Your Ref: OWPC3906
Our Ref: WA/48/14/PL 21-08-2014
Please ask for:
Mr D Sullivan

Demolition of existing commercial buildings/garages and erection of 3 No 2 bed terraced dwellings along with provision of ancillary parking, turning and landscaping (re-submission of application WA/52/13).

Deans Yard Orchard Way Fontwell

Proposed Site Layout

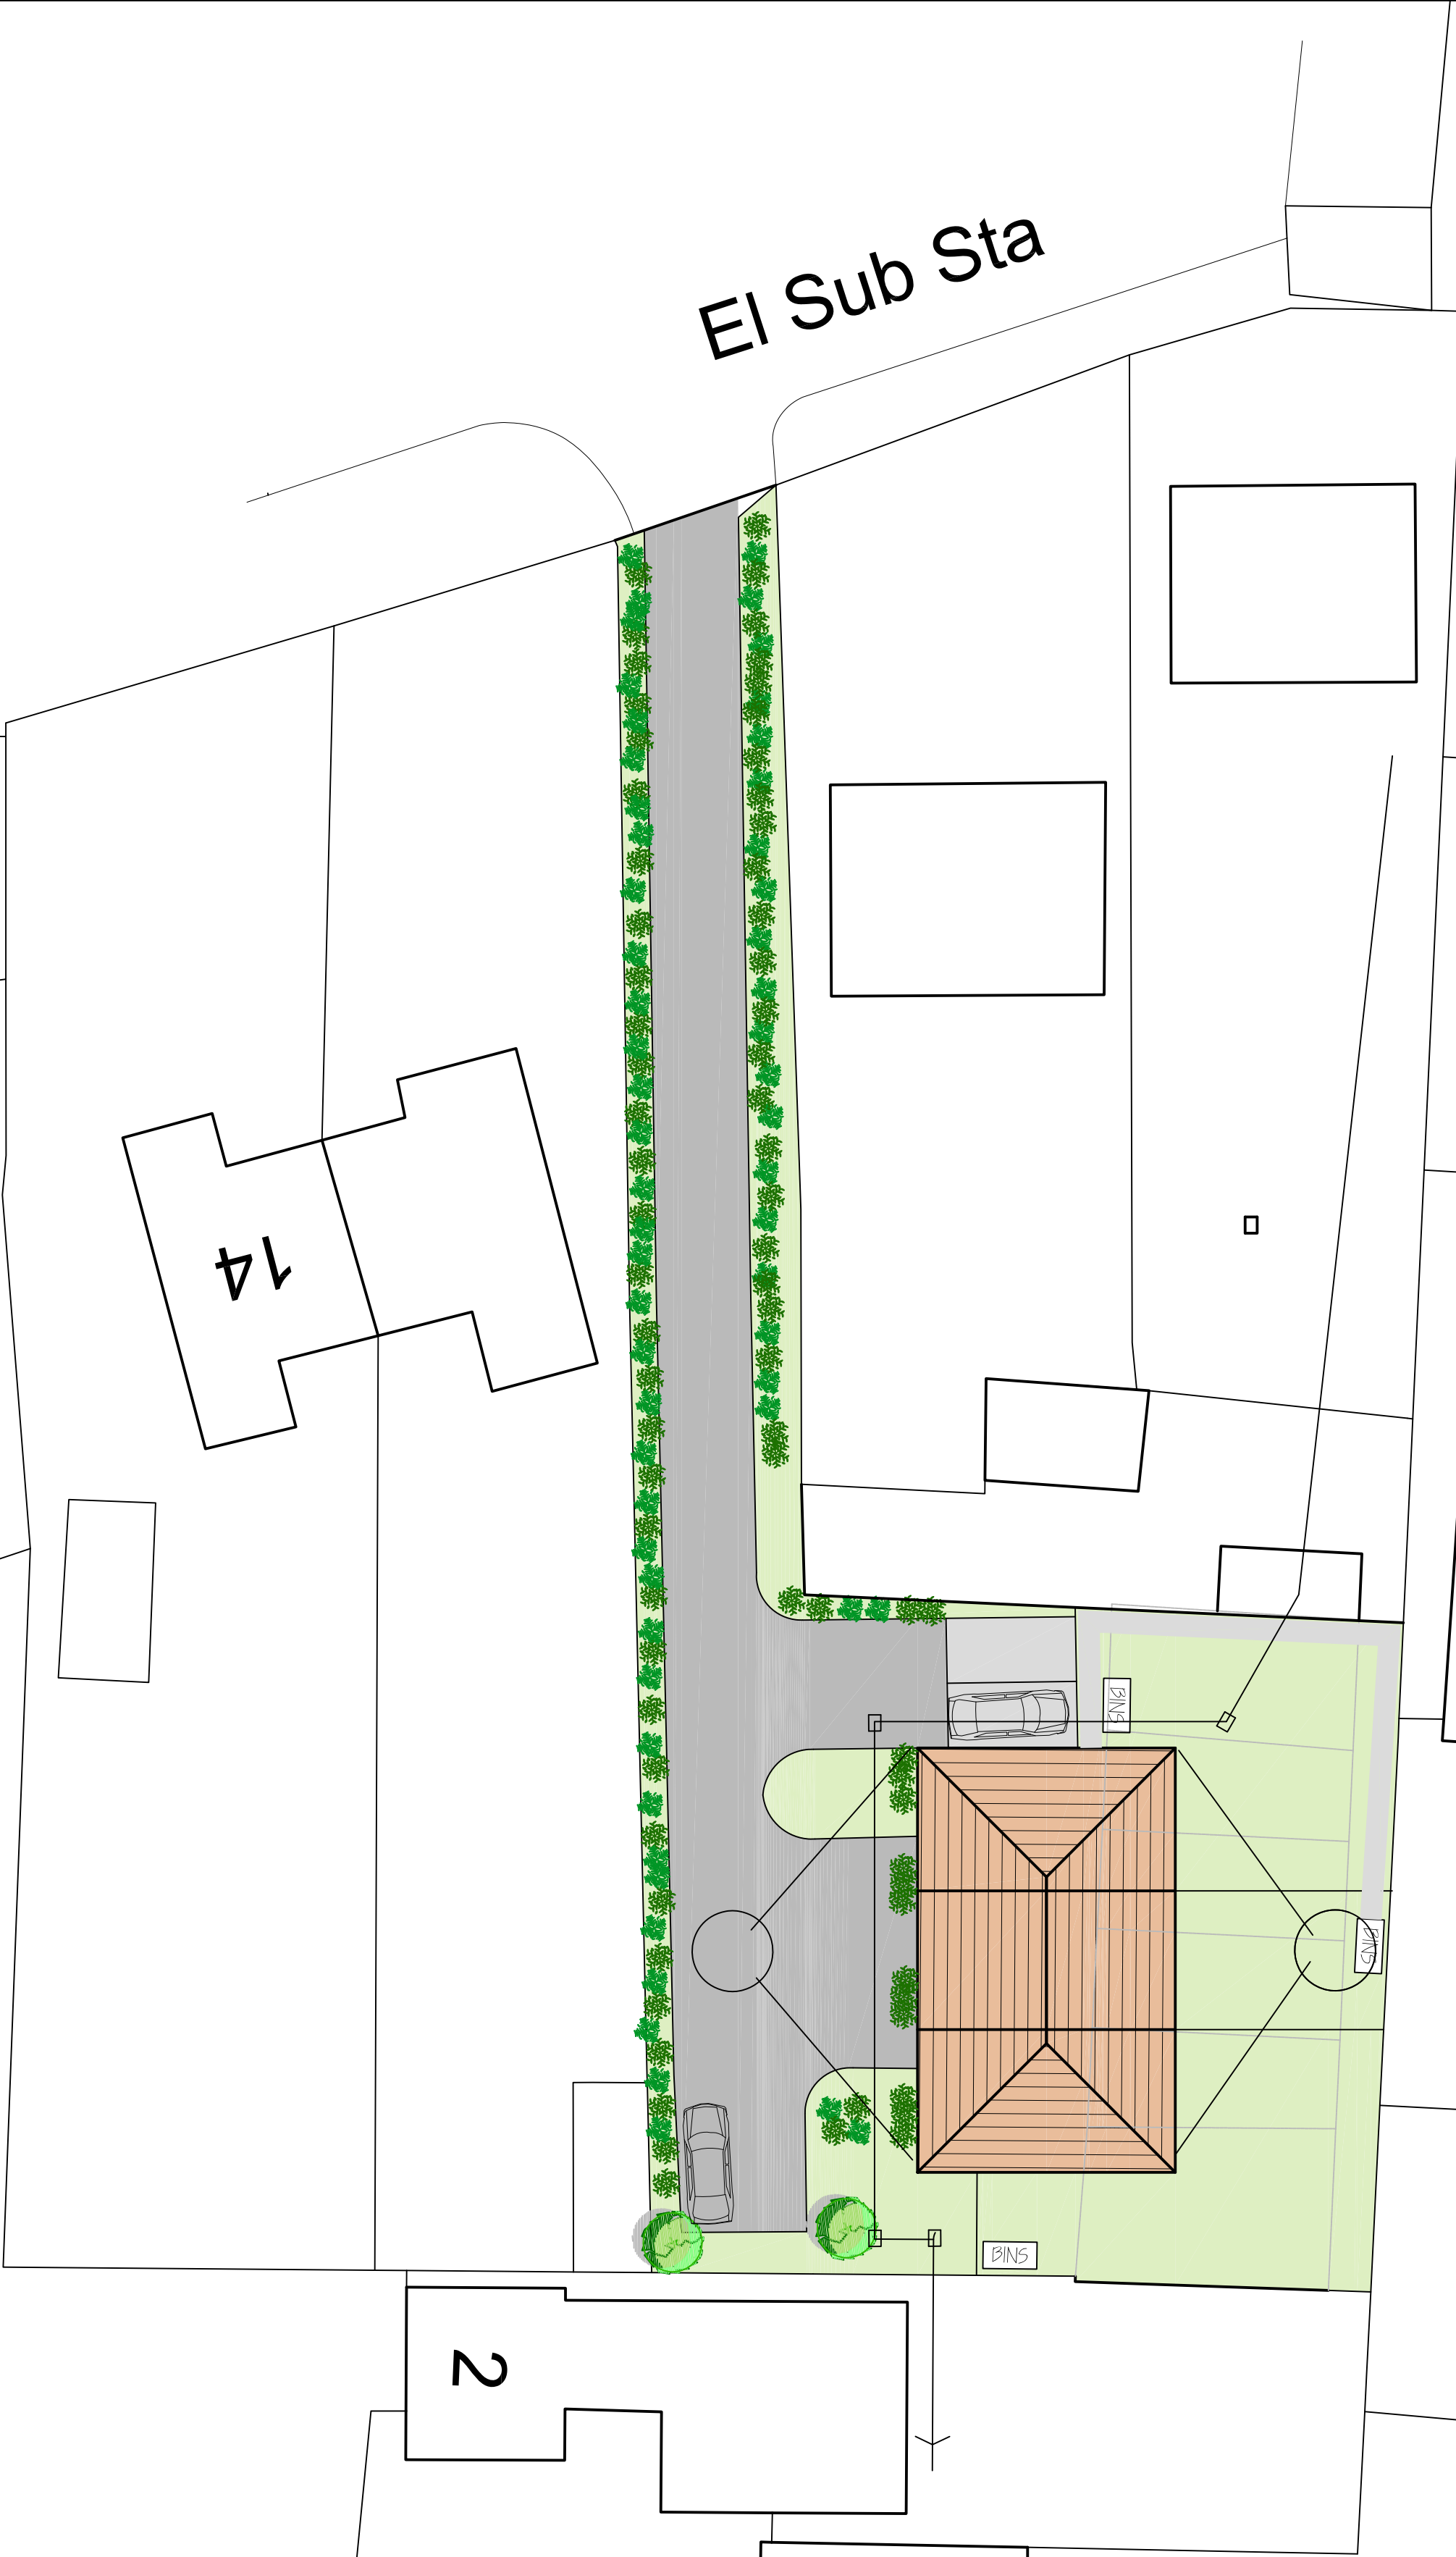
Although the position of the building on the site has been slightly altered the overall size remains the same. One of the points made in the decision to refuse consent was:- "the proposal by virtue of site coverage would result in an unacceptably cramped form of development that would be out of character with the pattern of surrounding development and as such would conflict with policy GEN7(ii) of the Arun District Local Plan and policies D SP1 and D DM1 of the Emerging Local Plan" (quoted from No 4 of the Decision Notice for Application Ref: WA/52/13, dated 7th May 2014)

Application Form No 7 and Block Plan - Block Plan clearly shows siting for bins, but no mention of where these will be sited for collection. At the present time, the refuse lorry does no access this narrow lane. If it is proposed for bins to be left at the top of Dean's Yard, I question where? Dean's Yard opens on to a private road where there is no hardstanding area for bins.

PROPOSED FIRST FLOOR LAYOUT PLAN

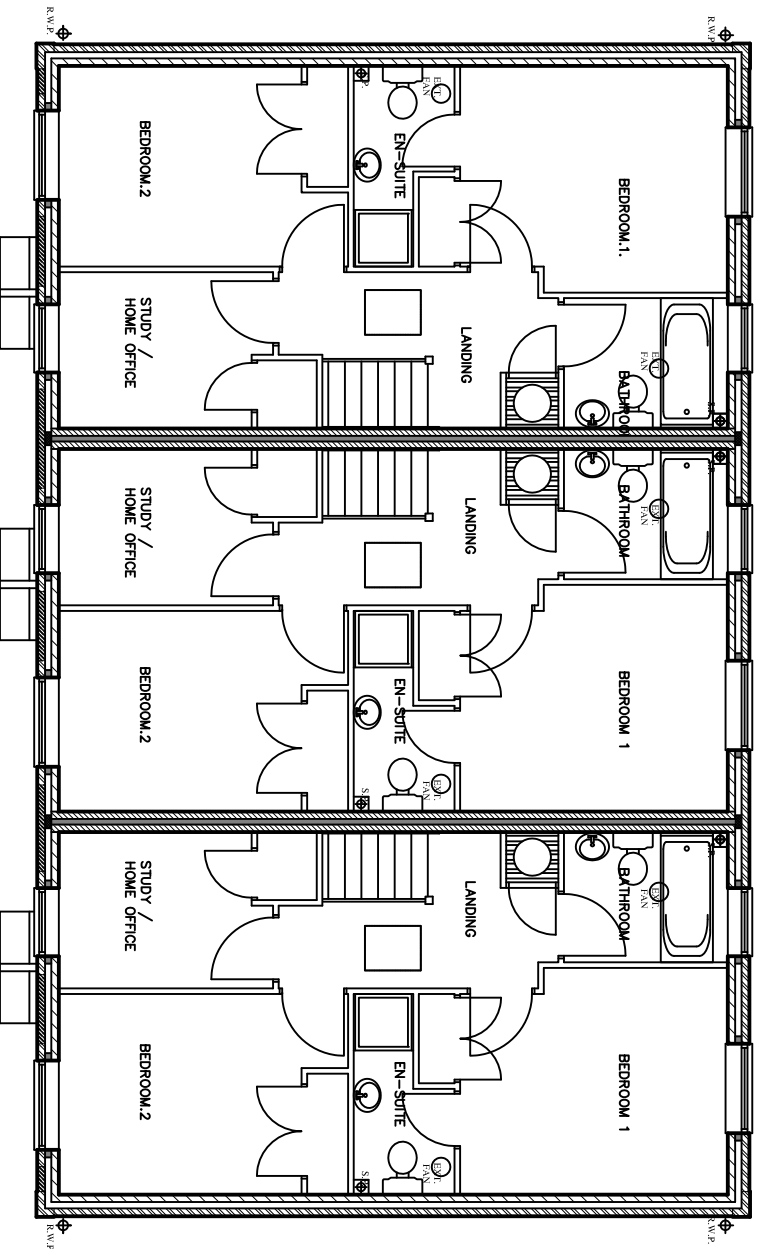
The amount of development is now defined as 2 bedroomed dwellings. However, it appears that the only change is calling the 3rd bedroom a 'home office/study'. The number of first floor rooms remains the same.
